Job reference: 2022 enquiry 59
Address: **rear extension at
No477 New Hey Road, Huddersfield**
Date: 19-4-2023 A
24-5-2023 addendum added at rear of report
Extra notes: **in response to house extensions and alterations SPD
for the rear extension at no477 New Hey Road, Huddersfield**

The statement is prepared in response to the house extensions and alterations SPD (June 2021).

Drawn No.
 107

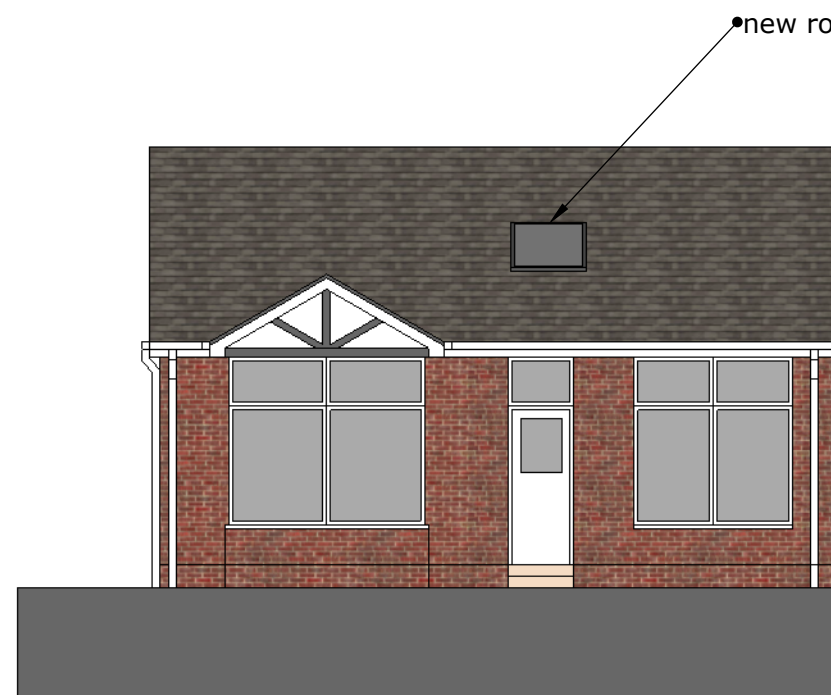
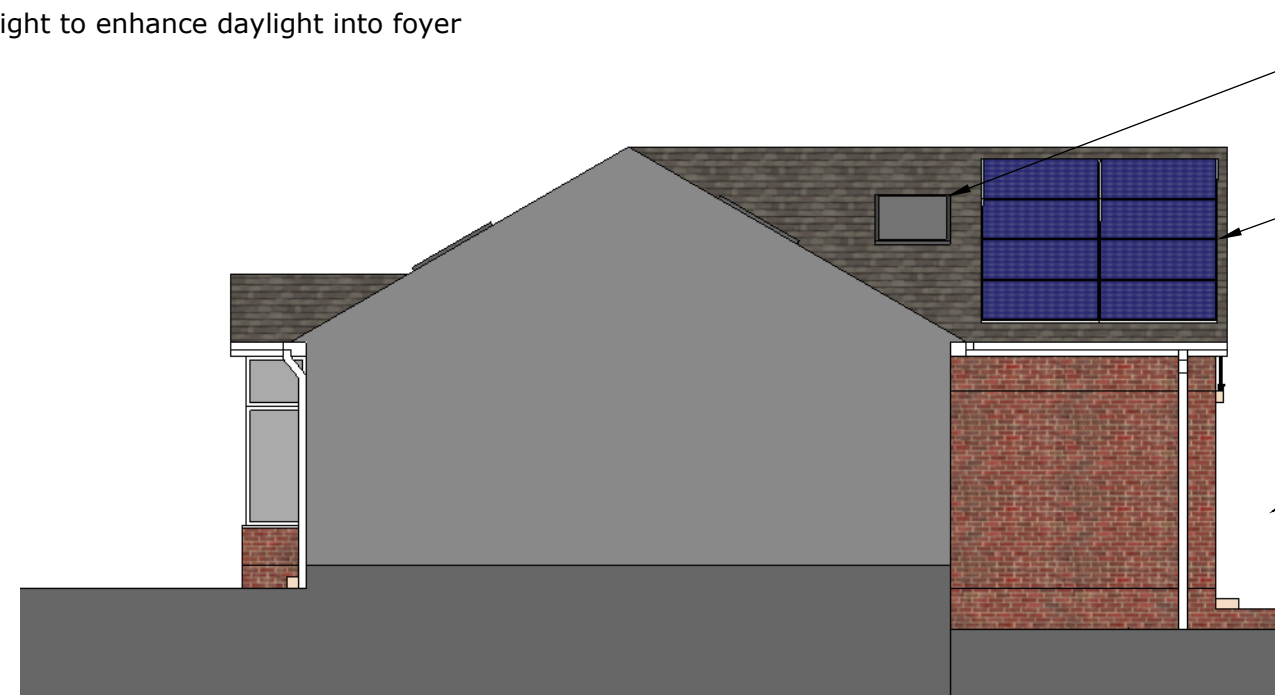
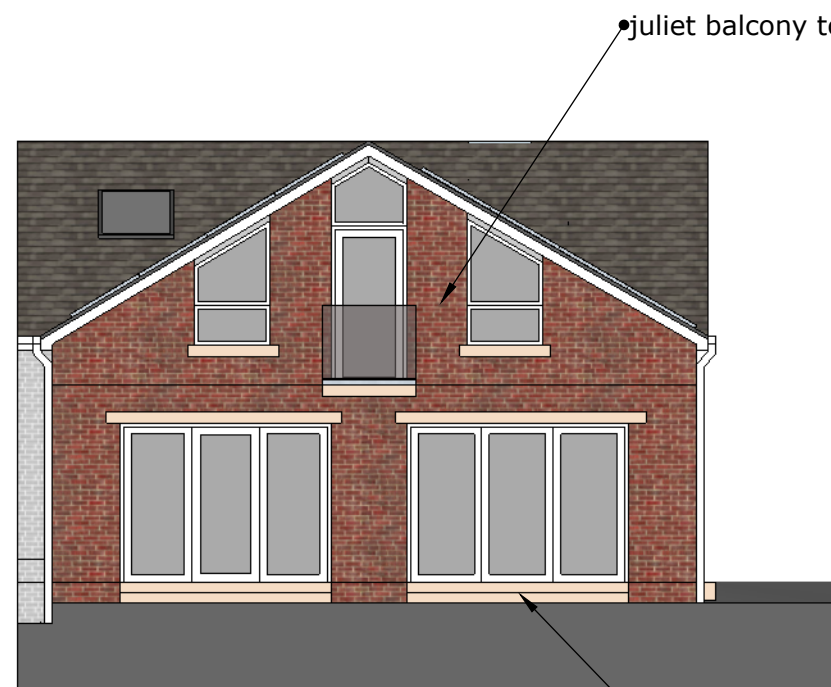
Following the planning application, the planner has asked for further justification on the current proposal against the adopted house extension and alterations SPD and mainly related to the LP24 policy on Design issue. We have spoken to the Team

Leader and she has suggested that the size of the extension should be extended from the original rear wall rather than from the existing kitchen wall. She also stated that although it is effectively a roof attic space accommodation, it is deemed as a first floor and as a result it is described as a 2 storey extension.

Noted and the rear garden size is more than 50% retained even after the previous rear extension have been completed. The previous rear extension extends out 3m from the existing rear kitchen wall. (however, it would be circa 5350 from the existing rear façade and the Team Leader felt that it would be a big extension) As a result, in order to work within the guidelines, the extension needs to be from the rear façade. It may seemed abit small and since the rear

garden is large, a proposal of 3.5m extension is created for your consideration. Not with standing this, building control requirements have changed and asking for walls U values to be improved. Therefore the wall depth now needs to be 350 wide rather than previously being 300 wide.

If 3000 width is proposed, then only 2700 internal based on the old building control regulation but would reduce to 2650 internal on the new building control regulations. It will make the extension small and therefore we seek a relaxation that 3500 is allowed which will achieve an internal width of 3150 which is more user friendly.

- *not project out more than 3 metres from the rear wall of the original house for semi-detached and terraces houses or by 4 metres for detached properties;*
the updated projection is 3.5m from the existing rear wall.

Drawn No.
112

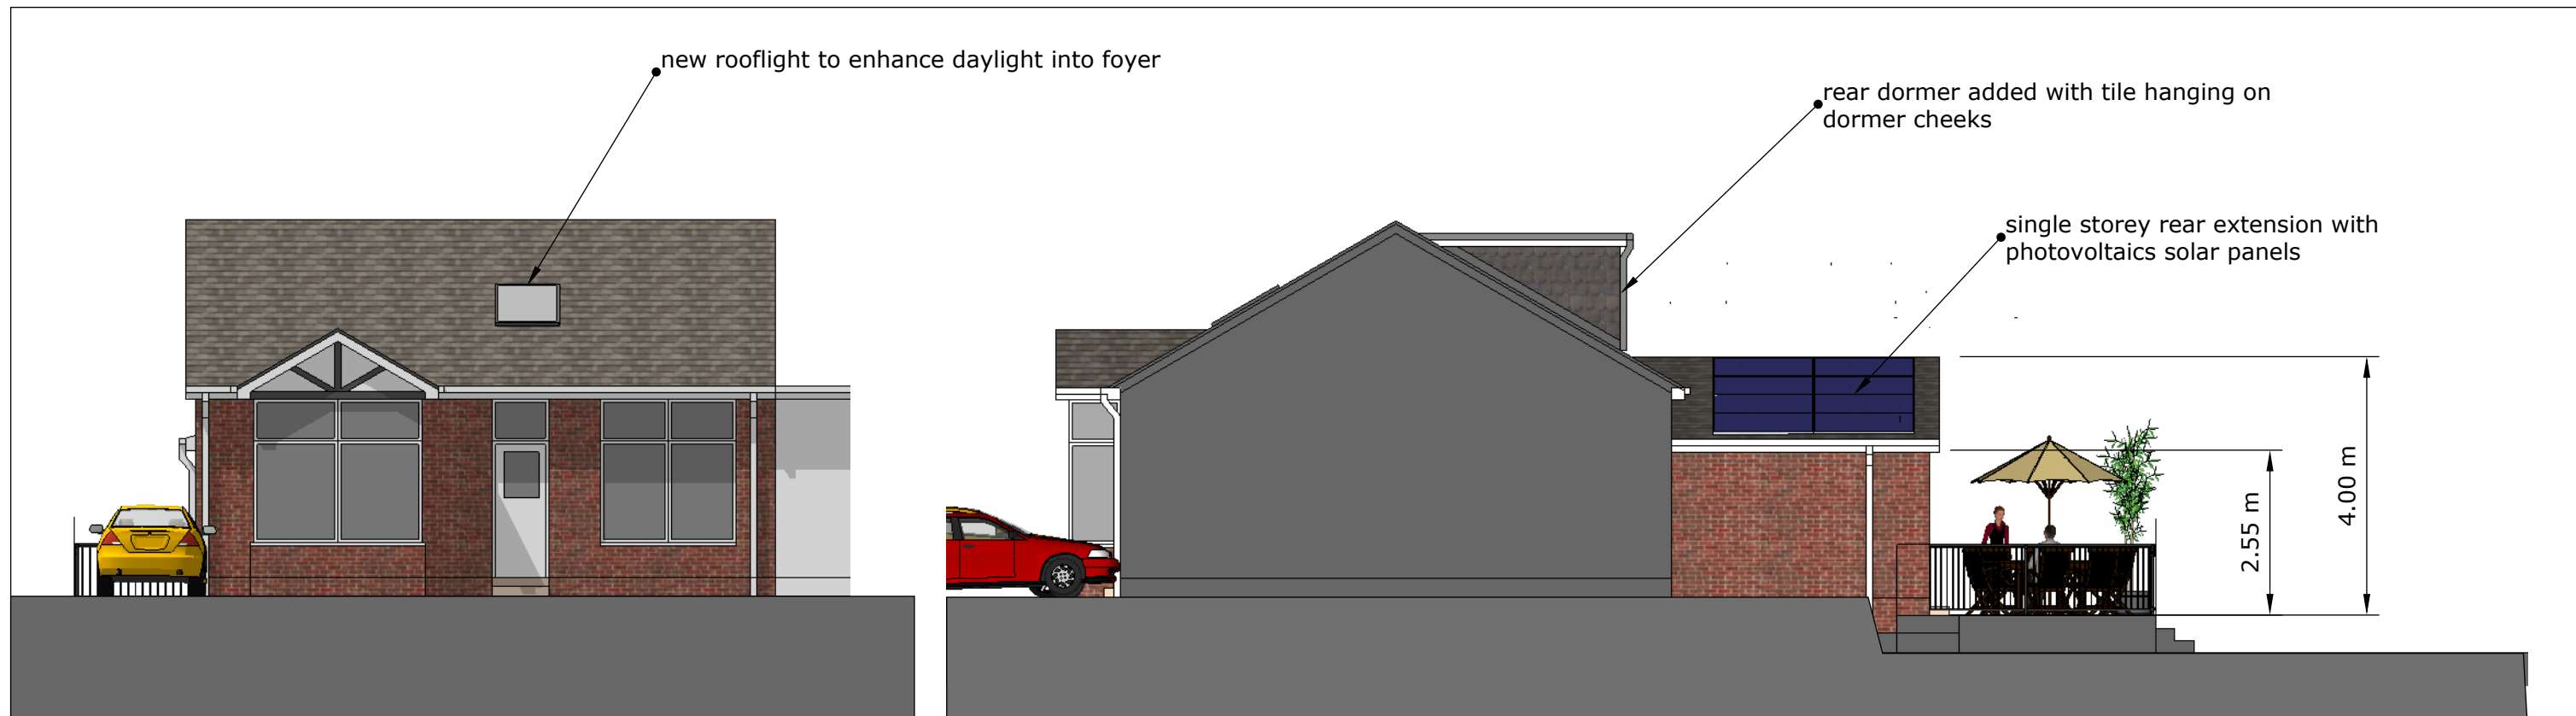
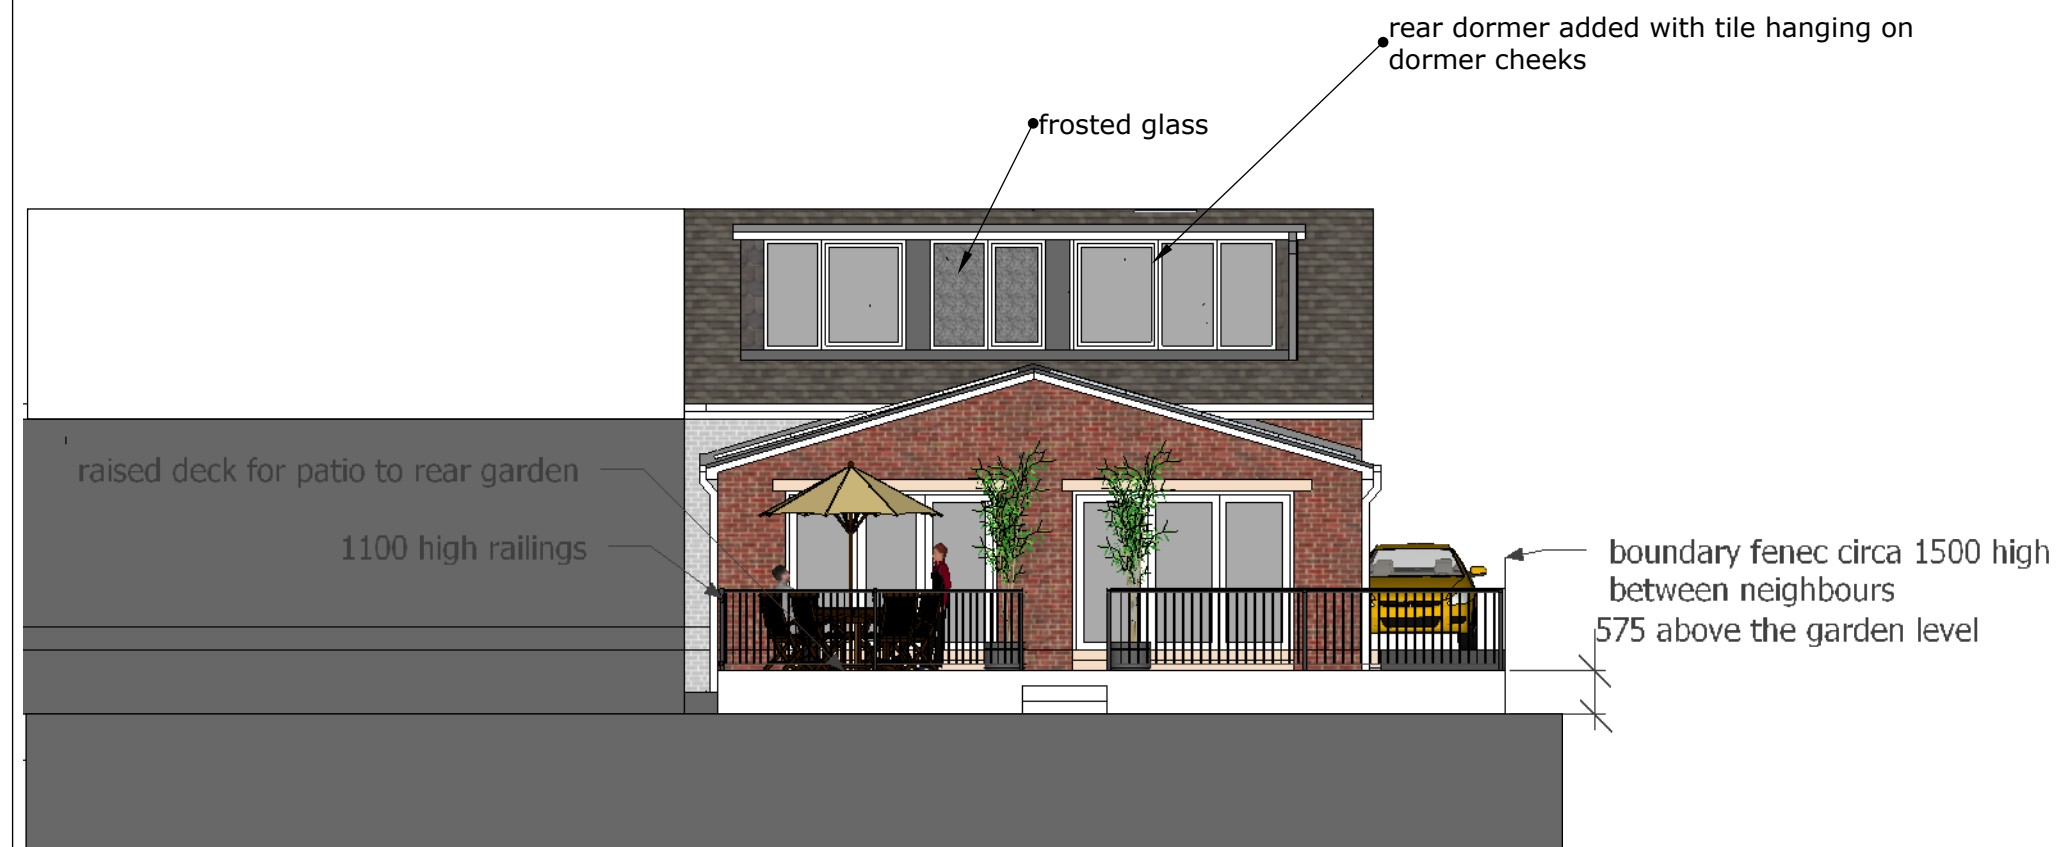
Following the submission of the application, the planner had deemed that the accommodation (even within the roof void) is deemed to be a 2 storey extension and NOT a single storey extension.

- *Preserving a back garden of a reasonable size, with a general principle that at least half the garden area is retained;*
Noted and the rear garden size is more than 50% retained even after the previous rear extension have been completed. The planner have suggested that the design reflect the single storey extension at the rear and 4m from the original rear wall as opposed to 3m. This is provided that the single storey extension is measured circa 2500 to the eaves and 4m to the roof ridge. The planner is willing to accept a rear dormer on the original roof as well.

This is now a single storey extension with the eaves and ridge height lower than the original dwelling but with a rear dormer added. The adjacent neighbour is also having similar size rear single storey extension and therefore this rear extension does not have any adverse impact on the immediate and adjacent neighbour.

- *not exceed 4 metres in height;*
the current extension is 4m high from external ground level to the top of roof ridge.
- *not project out more than 3 metres from the rear wall of the original house for semi-detached and terraces houses or by 4 metres for detached properties;*
the updated projection is 4.0m from the existing rear wall as suggested by the planner.

- *where they exceed 3m in length the eaves height should generally not exceed 2.5 meters;*
the current updated extension is 2.5m from external ground level to the underside of eaves. The new eaves actually is lower than the existing eaves.
